REVISION RESPONSE LETTER

**RE: Padmark Business Park, Filing 1
Vacation/Replat
File Number VR-17-005**

DATE: July 5, 2017

FINAL PLAT

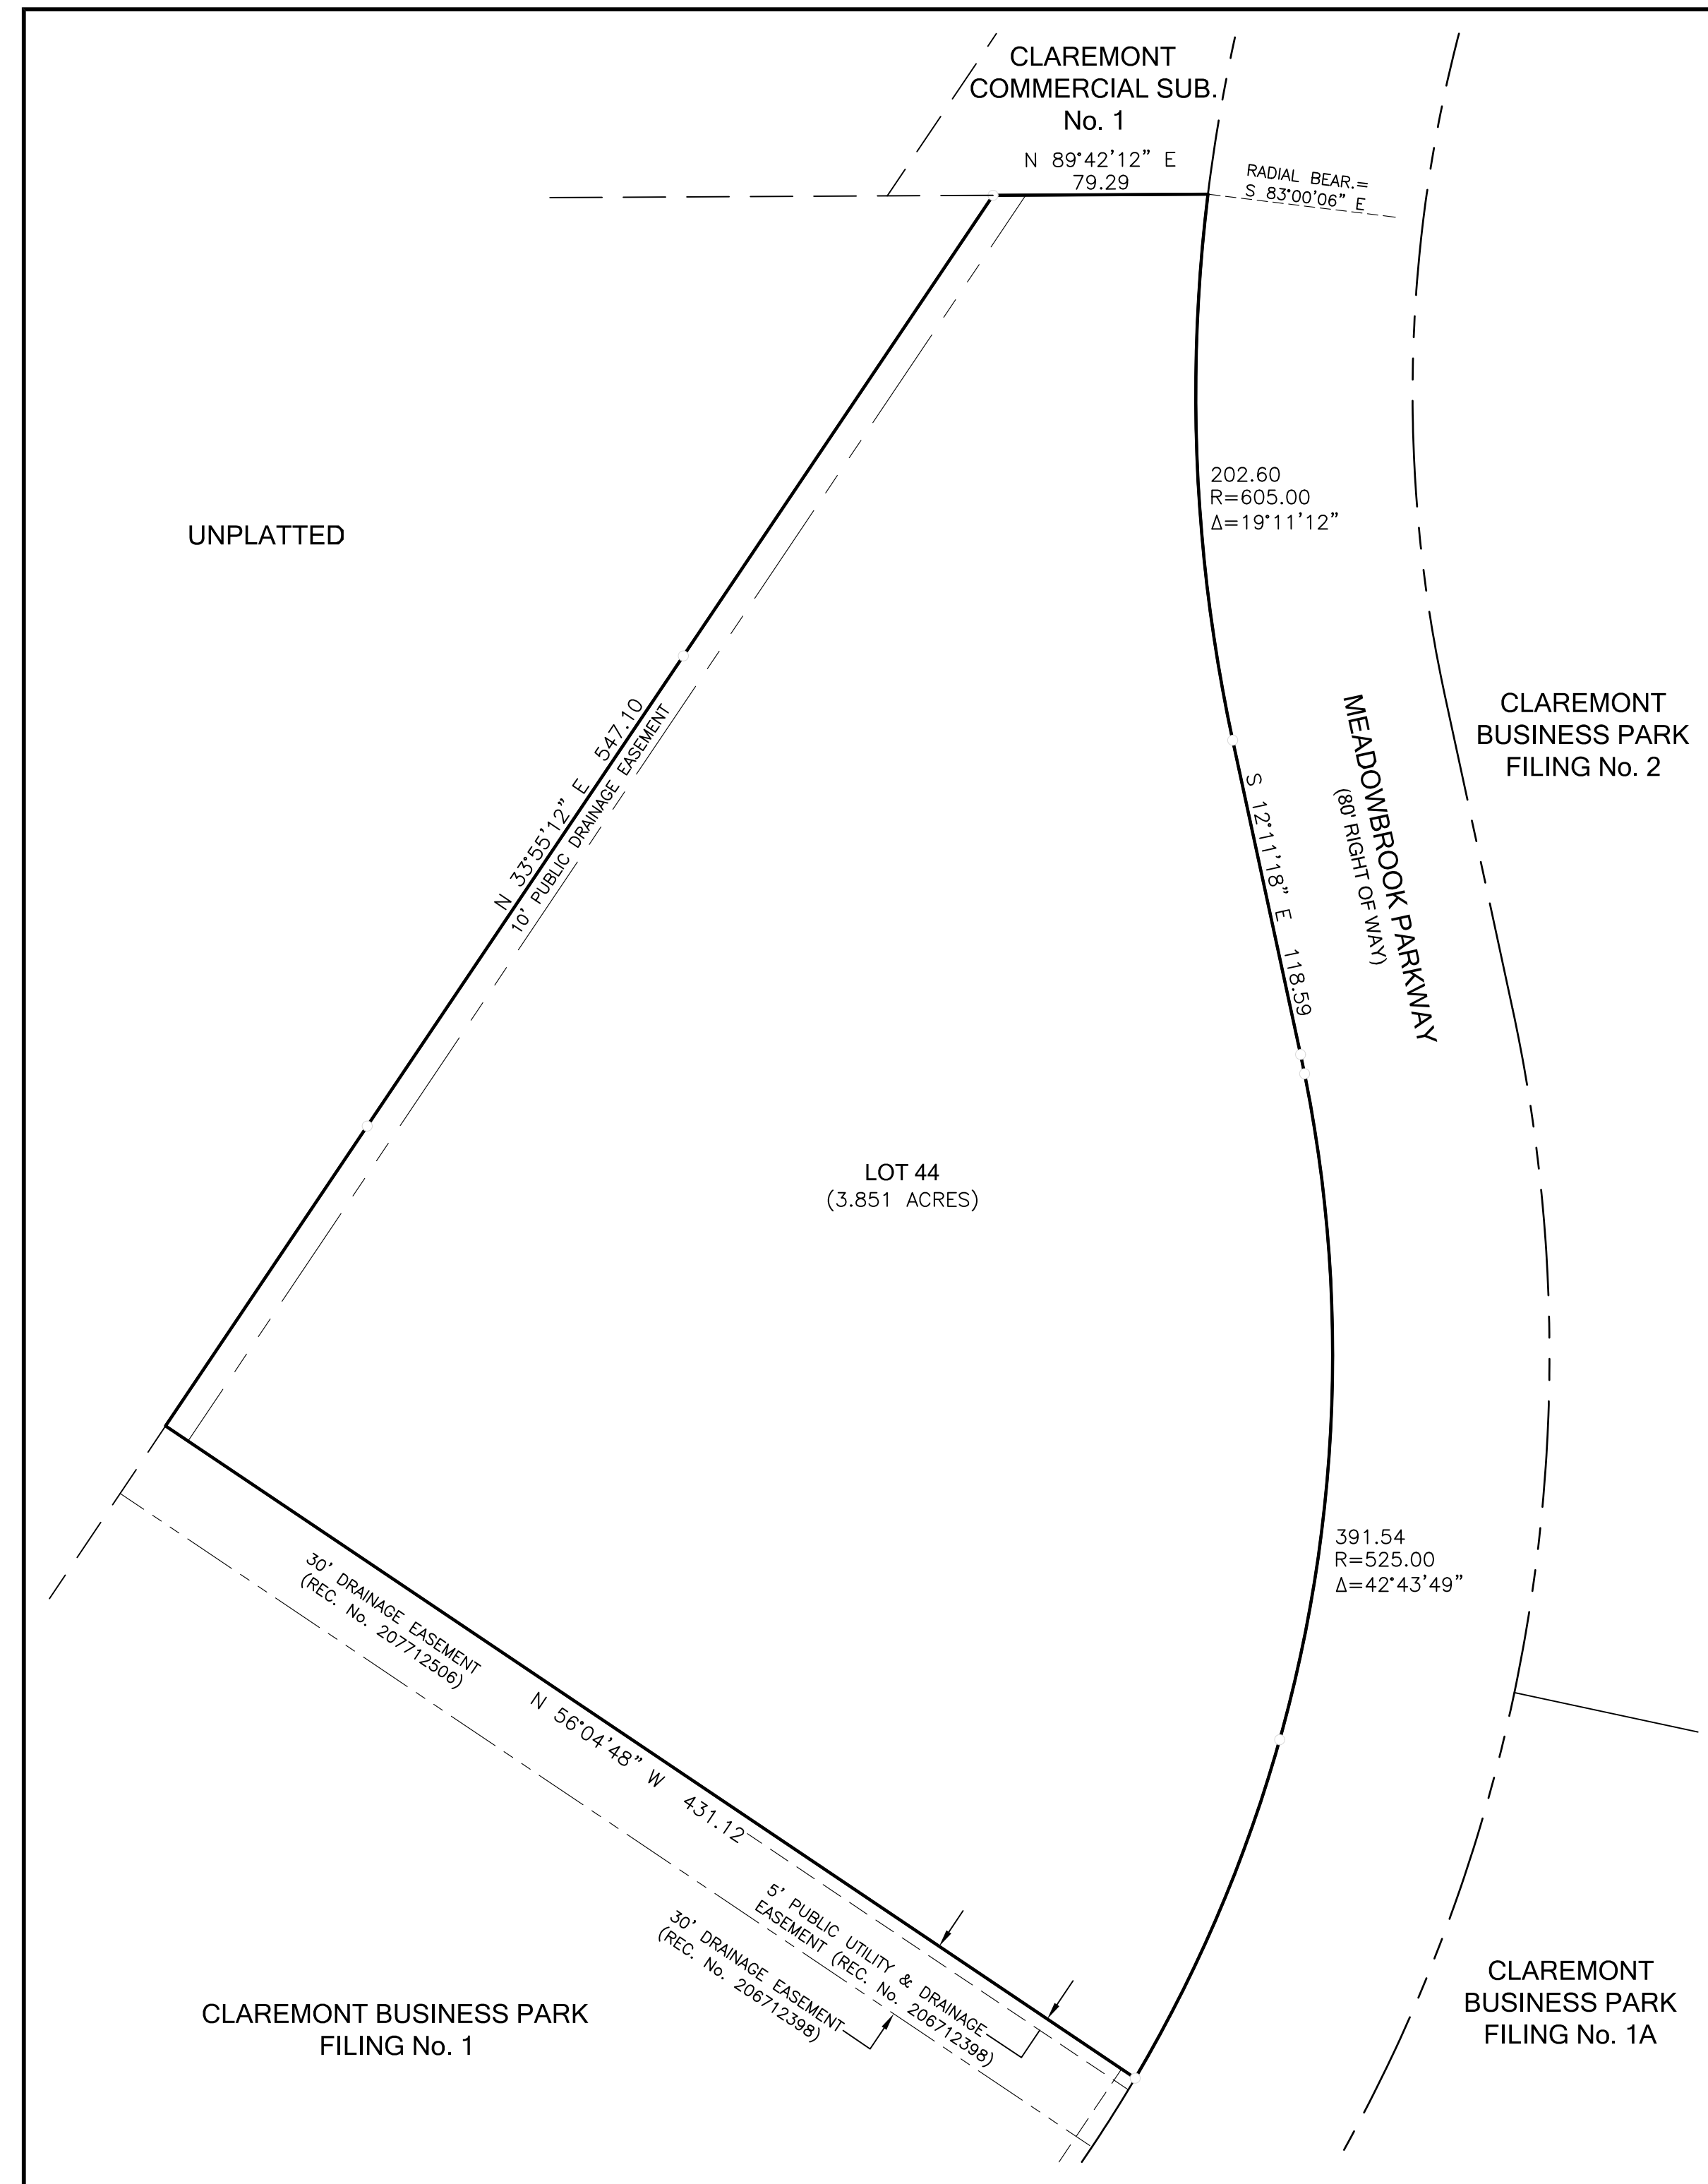
2. *Please verify all easements included in the title commitment have been shown on the plat.*
All plottable easements are shown
3. *The letter of intent does not address all review criteria for a final plat or the County Policy Plan. Please revise.* **Updated**

AS REPLATTED

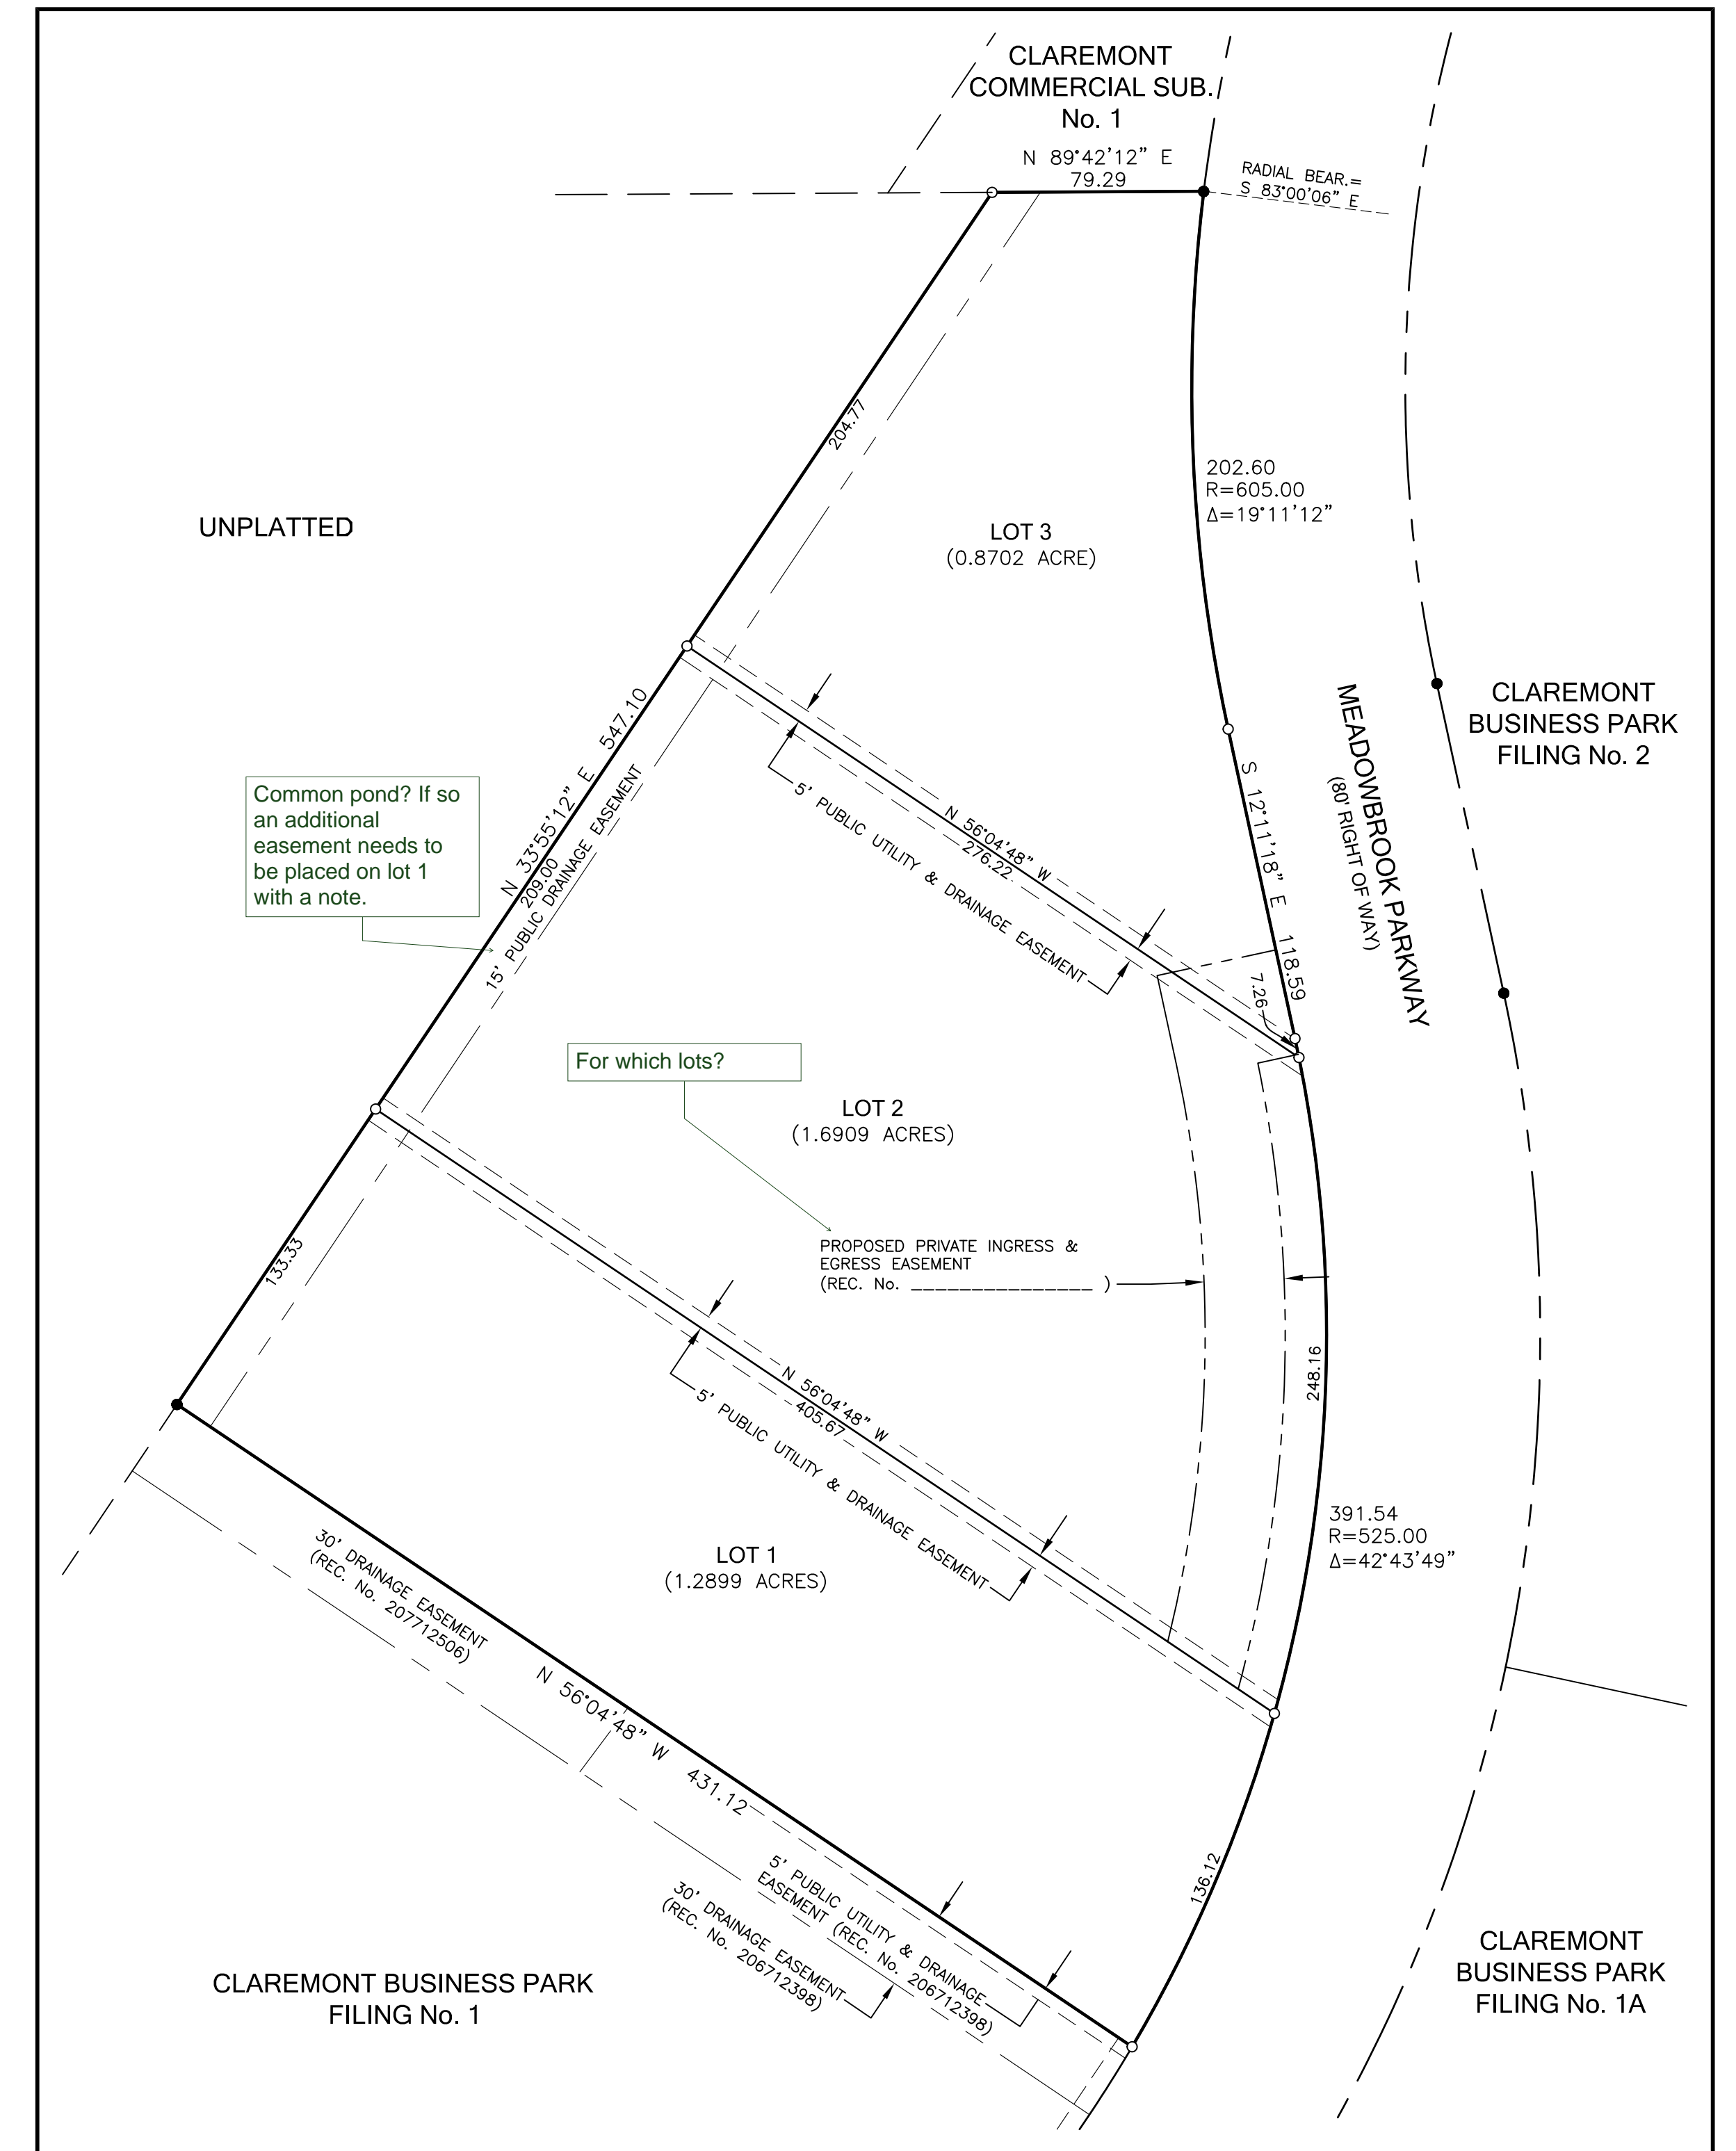
- 1. Ensure that each lot has the required 5ft side-lot public utility easement (Specifically for the southern property line of Lot 1 and the northern property line of Lot 3). **A retaining wall and curb and gutter are proposed to be constructed within 3 feet of the southerly line of Lot 1. All services to the building on Lot 1 will come from Meadowbrook Parkway. The property adjacent to Lot 1 is developed. Therefore, an easement along the southerly line of Lot 1 is most likely not necessary.***
